BUILDING INSPECTION PERMIT

Permit Number: 060894

has permission to Replace existing deck w/ a screen porch

AT 26 CARTER ST

Greg + Tracey DuLac Carter St. #26

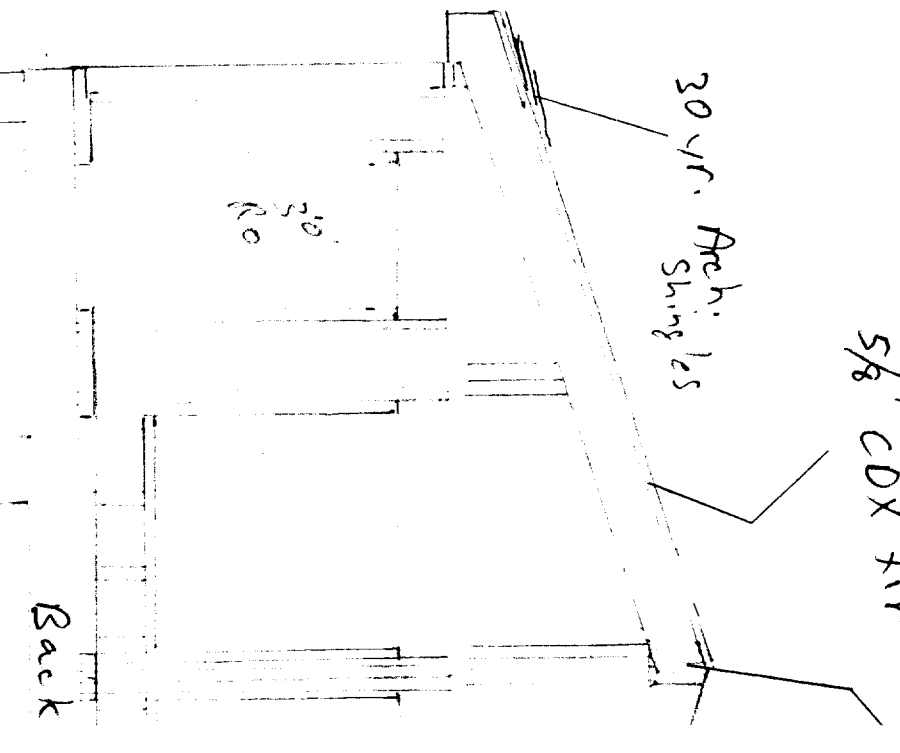
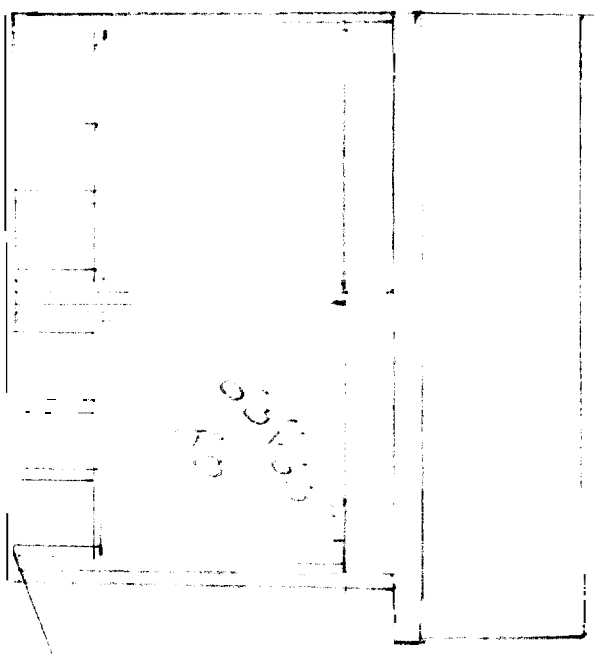
- 1) The Band Joist will be two (2) 2" x 12" members. There will be 5 sonor tubes supprting this, one in line with the ridge beam.
- 2) 9. Where a wall of a dwelling serves as part of the barrier one of the following conditions shall be met:
